DECISION DELEGATED TO HEAD OF PLANNING

Application No: H23-0407-23 **Applicant:** Mr D Ford
Proposal: Demolition of existing barn and erection of 2 detached dwellings
Location: Carters Farm Oxcroft Bank Shepeau Stow
Terminal Date: 12th October 2023

Job Title Proposed Dwellings Carters Farm, Oxcroft Lane, Shepeau Stow For: Mr Ford	Date April 2023	Drawn by CW Checked by GE
Drawing Title Planning Drawing Site Plan & Location Plan	Job No. SE-1951 Dwg No. PP1000	Sheet Size A1 Revision

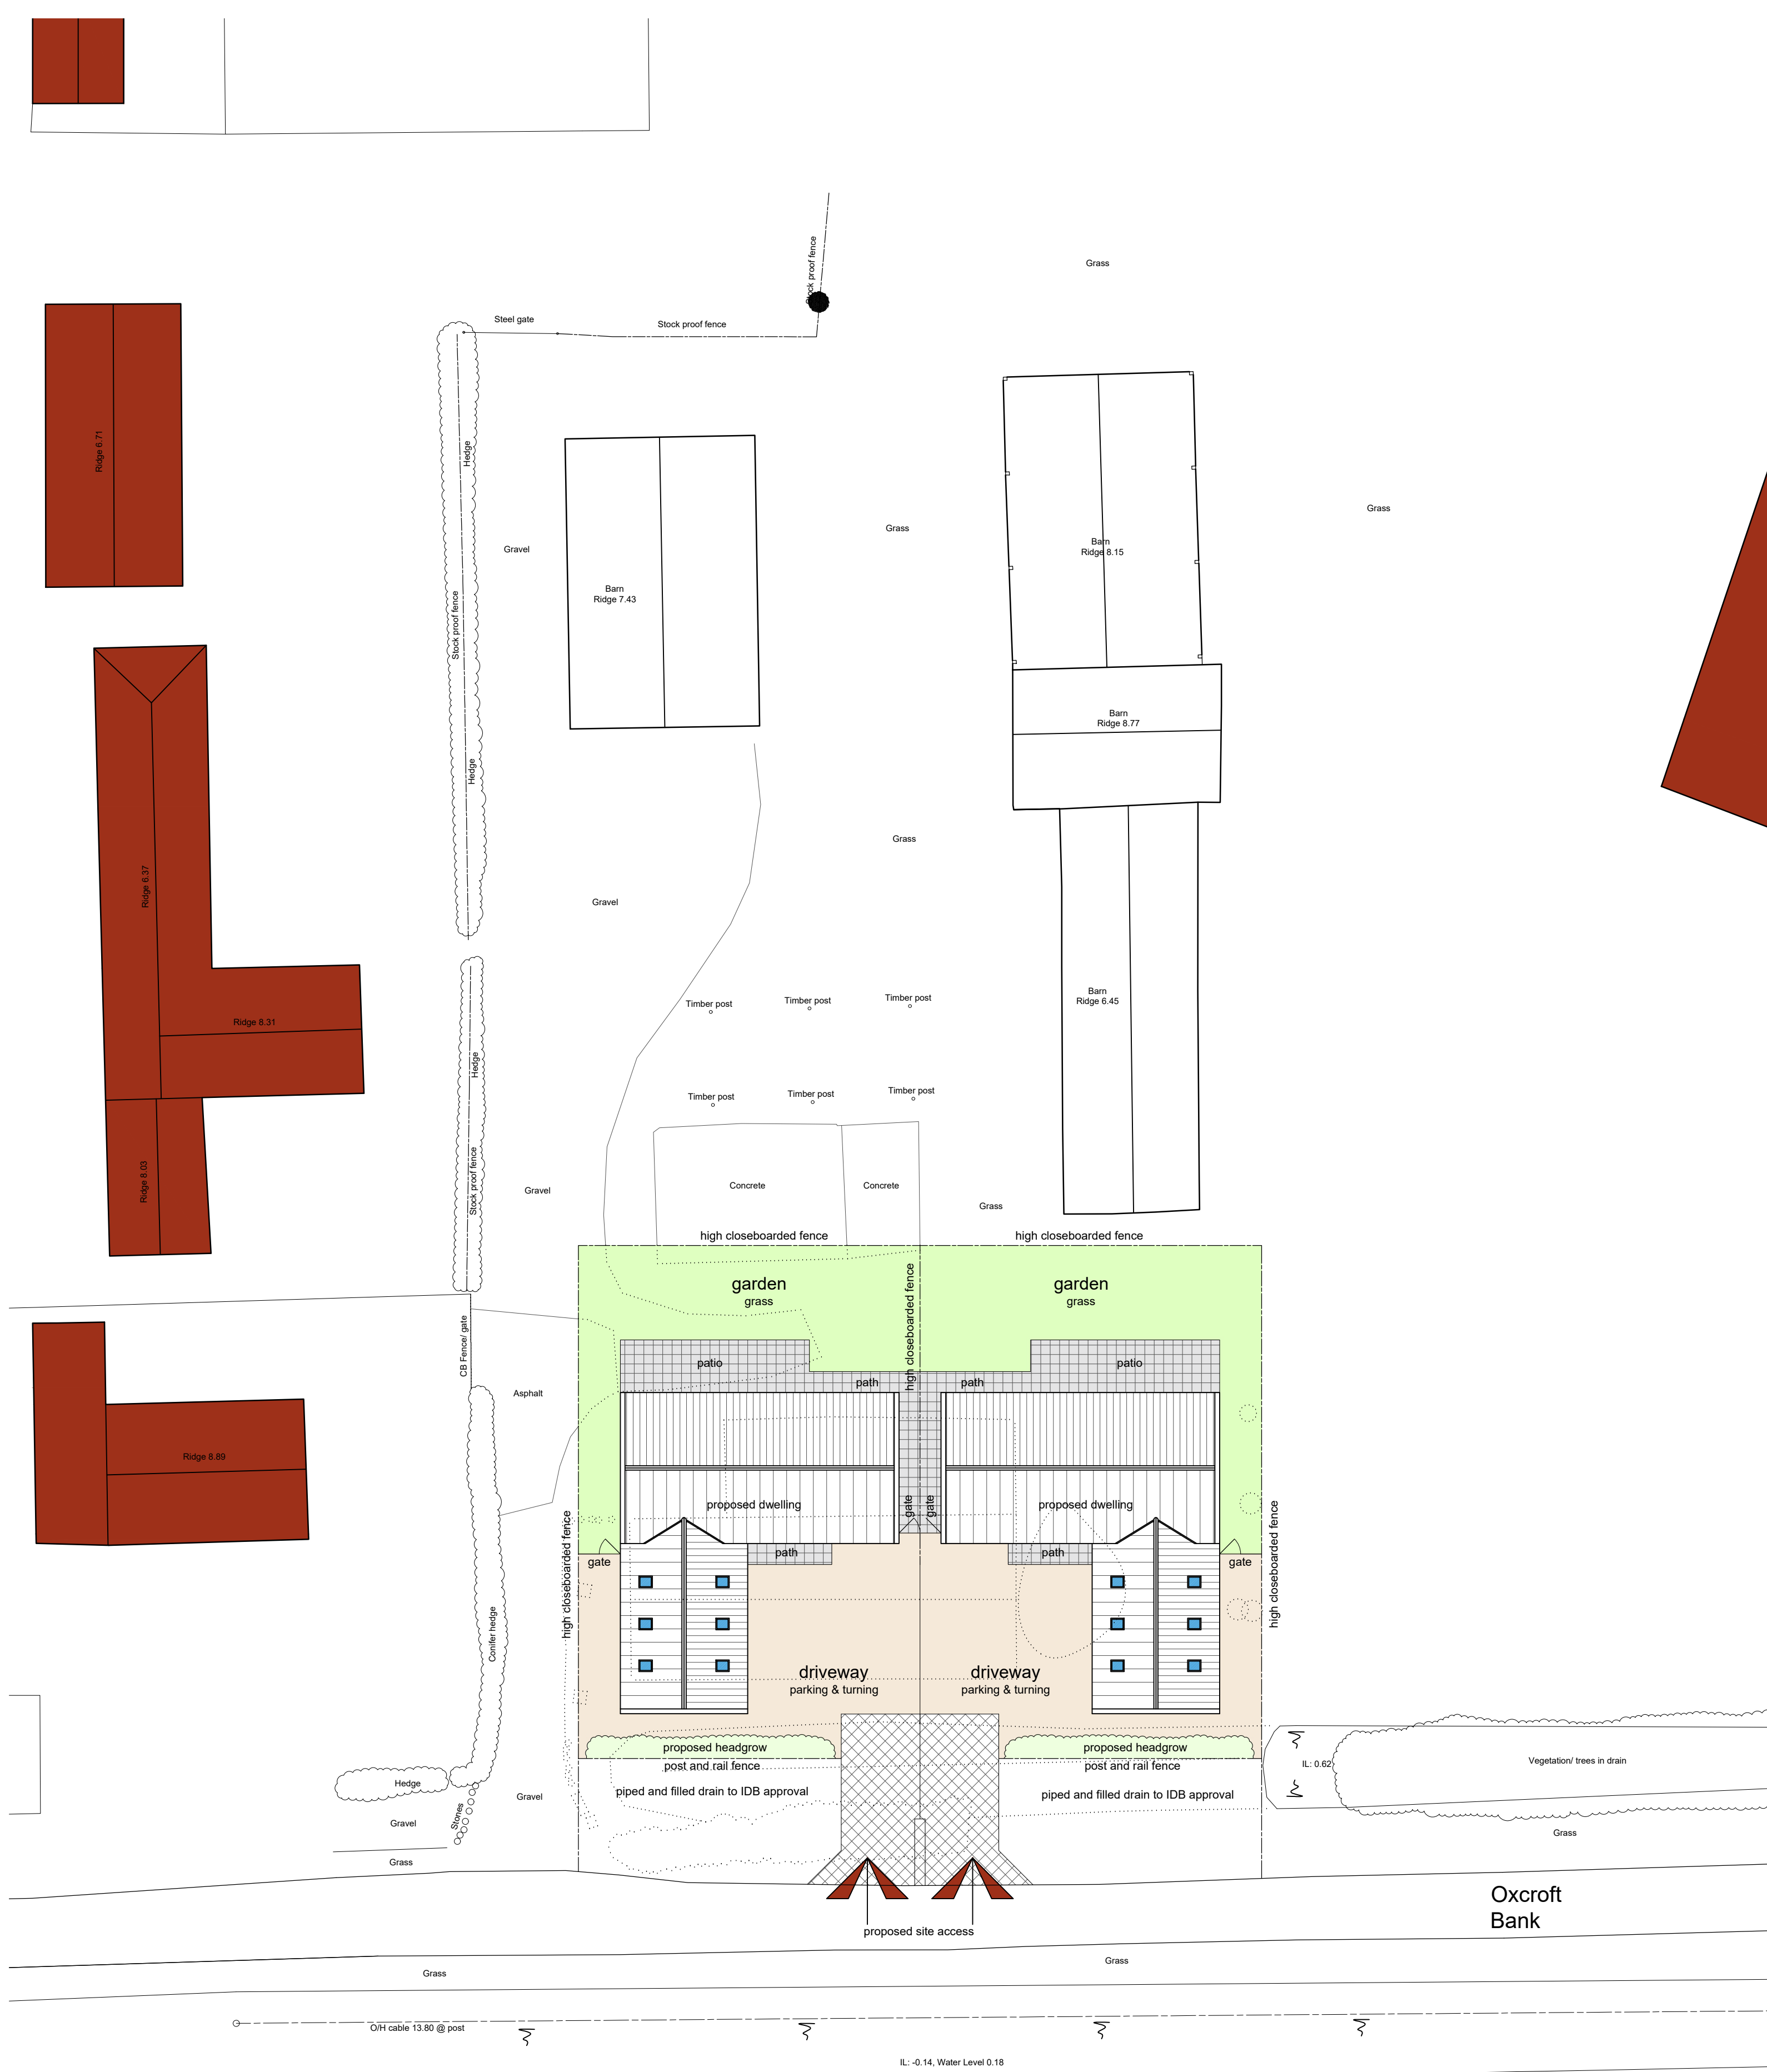
- Piping of drain - Altered access arrangements. Proposal to pipe and fill ditch could have a detrimental impact on local ecology and drainage - it is requested that this matter be further investigated with a phase 1 ecology report. The piping of drainage ditches is generally avoided as it is harmful to the ecology of the ditch, and fundamentally changes the appearance of the site.

The principle of two residential units has already been established. The form of development proposed requires the formation of a new vehicle access crossing in the centre of the site's frontage. This would not be in a position where visibility would be obstructed for drivers emerging from the site into the highway and would therefore be acceptable. The existing vehicle access is to be removed and returned to grass verge.

The PEA report indicates that there may be a local potential significant ecological impact in respect of bats and possibly amphibians within the frontage ditch. In terms of the latter, the applicant no longer proposes to culvert the frontage ditch, other than the access point. The report goes on to stress that no further surveys are required other than a single survey for roosting bats in respect of the barn (low potential) and that two further surveys would be necessary if bats were found to be roosting.

Rear Elevation (SE)

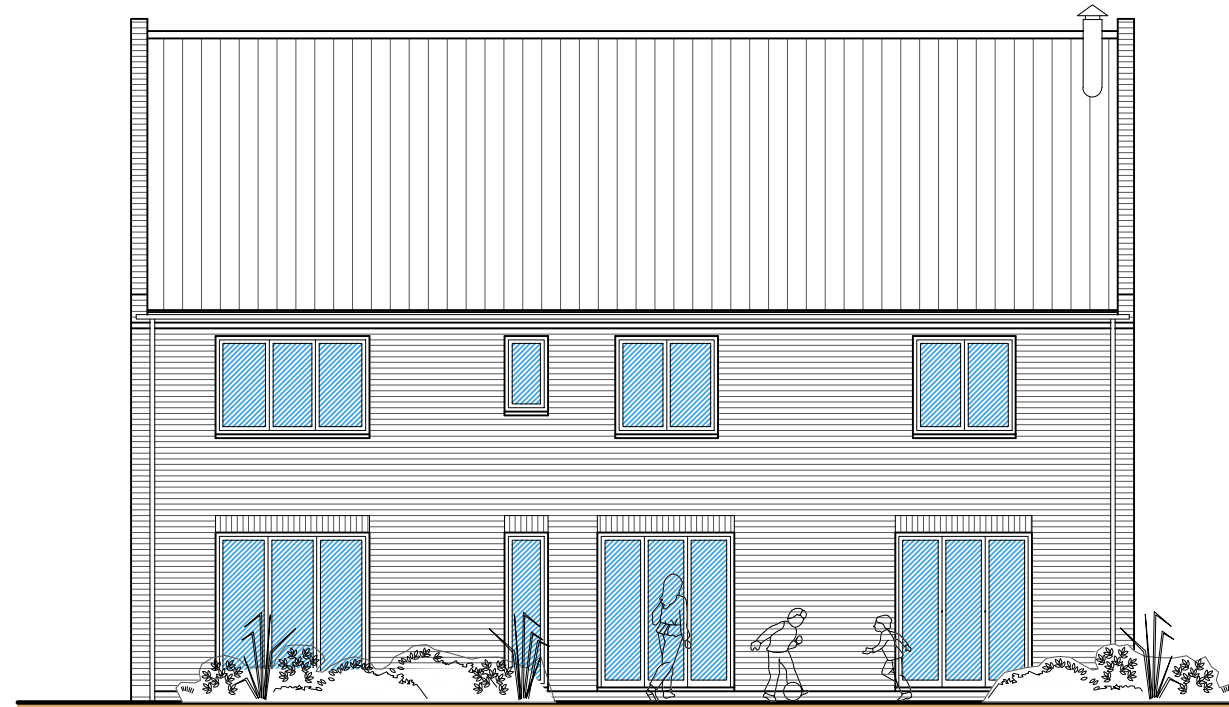
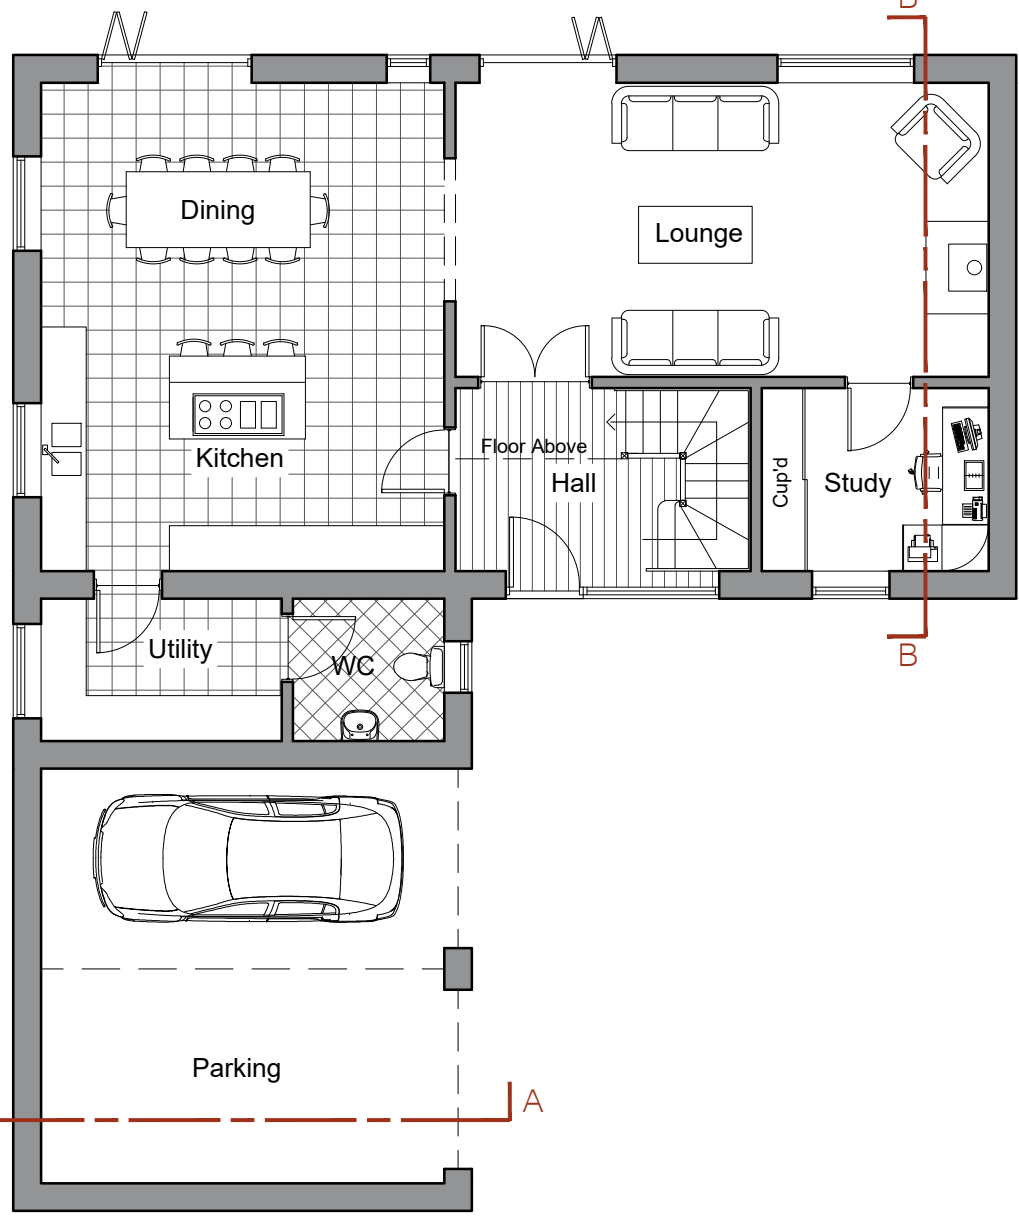
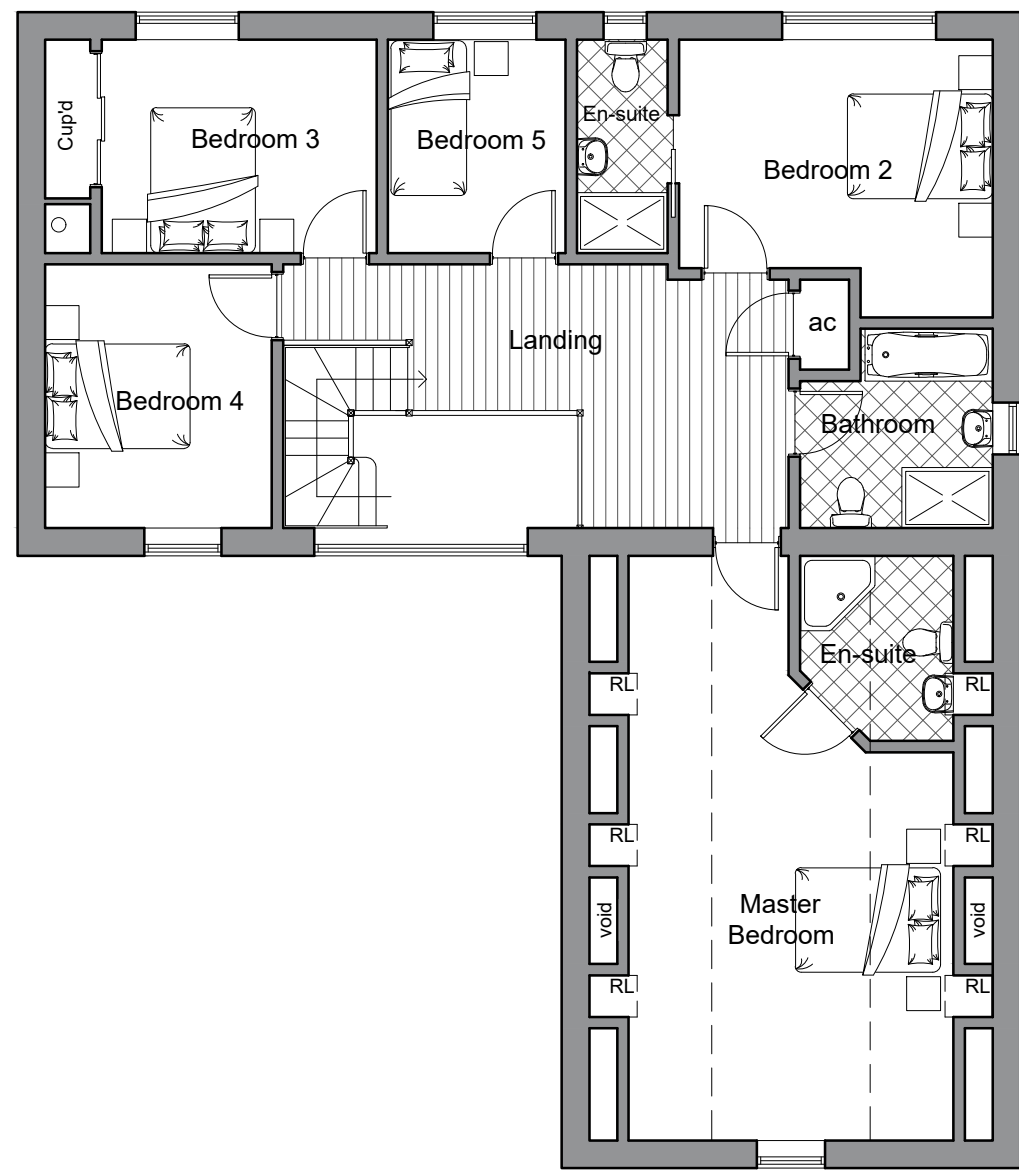
- Overlooking and loss of amenity - Excessive and intrusive levels of overlooking from first floor windows on rear of the northern most plot to the private garden area of Nods Nook Barn, which is contrary to policy 3 which seeks to protect residential amenity from unacceptable impacts from new development. In addition to the loss of privacy in the garden, both plots will be able to look into a number of rooms on both ground and first floor level of Nods Nook Barn.

At first floor level, the dwelling on the northernmost plot has bedroom windows on its rear (SE) elevation and a bathroom window on its side (NE) elevation. It is separated from Nook House and Nods Nook Barn by a private roadway serving the aforementioned, plus the farmyard at the rear. Nook House has its principal elevations facing the front and rear and has a high leylandii hedge along its south-western boundary. Nods Nook Barn has openings on its south-western/north-eastern elevations associated with primary rooms such as a living room, kitchen, bedrooms, etc, plus a private garden and 2 metre plus native hedging along its south-western boundary adjoining the farmyard.

Nook House is situated approximately 14 metres from the side elevation of the northernmost plot, which has a bathroom window only at first floor level. The boundary of Nods Nook Barn adjoining its private garden area is approximately 11 metres from the nearest bedroom window serving bed 2 and the converted barn itself some 19 metres. Also, overlooking would be oblique, plus a hedge exists at ground level along with a new close boarded fence serving the development.

Taking all factors into account it is considered that the amenity of neighbouring residents would not be materially harmed in terms of overlooking, lack of privacy, overshadowing, overbearing effect, noise and disturbance, etc. In terms of the latter, consideration has been given to the fact that the site was formerly part of a working agricultural holding/nursery.
